Ribble Valley Borough Council
Housing & Development Control

Your ref: 3/2023/0946
Our ref: D3.2023.0946
Date: 19th January 2024

Application no: **3/2023/0946**

Proposal: **Retention of re-positioned access gate and stone track off Slaidburn Road.**

Proposed Access
Scale 1:500 @ A3

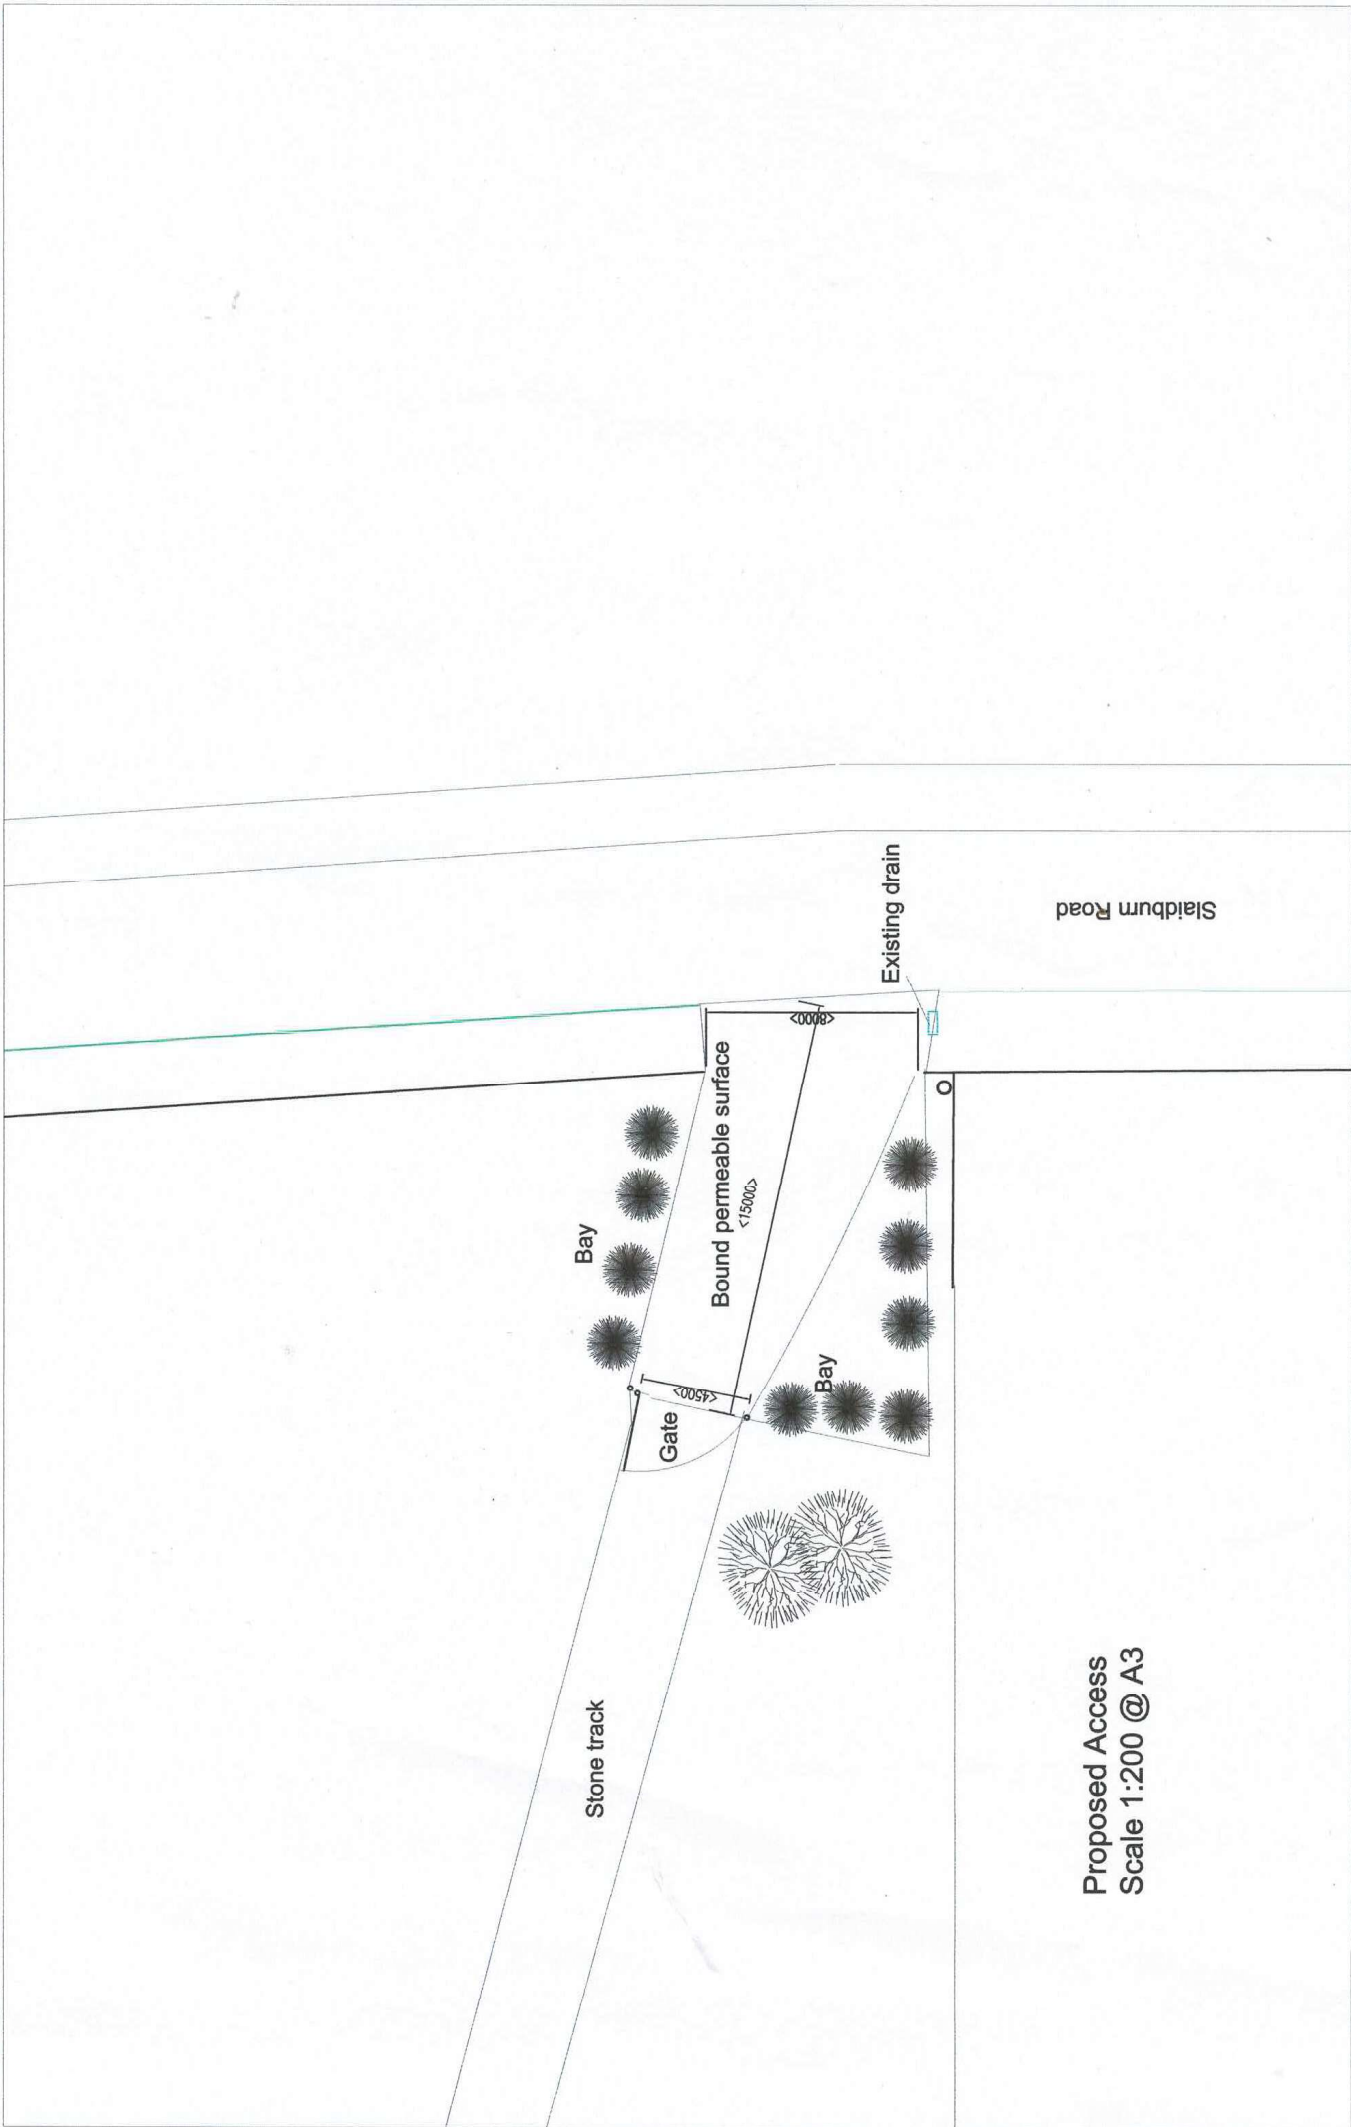
The LHA have reviewed the drawing titled "Visibility Splay and Access Design" and note that the access will be widened to 8m wide. The width will then eventually reduce to 4.5m, at a distance of 15m from the adopted highway where the access to the internal track will be gated.

The drawing also shows that appropriate levels of visibility can be achieved along the 60mph road. However, the visibility splays are not drawn correctly, with the LHA only being able to accept the splays being drawn to an offset of 1m from the kerb line given that the carriageway can accommodate two-way movements. Therefore, by reviewing the submitted drawing as presented, the LHA have conducted their own assessment which found that the site can achieve approximately visibility splays of 2.4m x 63m to the north and 2.4m x 35m to the south.

The LHA have further reviewed the drawing titled "Visibility Splay and Access Design" and are aware that the site is proposing to maximise visibility by maintaining the vegetation and reducing the height of the wall to 0.9m to the north of the site. The LHA welcome these measures and will condition that they are undertaken under a Section 278 agreement.

Under a Section 278 agreement, any improvements to the site access will also be included. This will include surfacing improvements and providing a kerb line along the highway edge. The LHA also advise that the site access could be further improved and formalised by providing a kerb radius on both sides of the site access which will aid turning movements into the site.

The LHA further advise that the telegraph pole located adjacent to the site access may need to be relocated as part of any subsequent works with it being located approximately 0.5m from the access.

1. No part of the development hereby approved shall commence until a scheme for the construction of the site access and the off-site works which includes maintaining vegetation and lowering the height of the wall to 0.9m to the north of the site access has been submitted to, and approved by, the Local Planning Authority in consultation with the Highway Authority.

2. No part of the development hereby permitted shall be occupied until such time as the access arrangements shown on drawing titled "Visibility Splay and Access Design" have been implemented in full.

3. The development hereby permitted shall not be occupied until such time as the access drive (and any turning space) has been surfaced with tarmacadam, or similar hard bound material (not loose aggregate) for a distance of at least 11 metres behind the highway boundary and, once provided, shall be so maintained in perpetuity.

4. Before the development hereby permitted becomes operational, the existing wall and vegetation along the highway frontage of the site shall be reduced to and be permanently maintained henceforth at a height no greater than 0.9m above the nearside carriageway level.
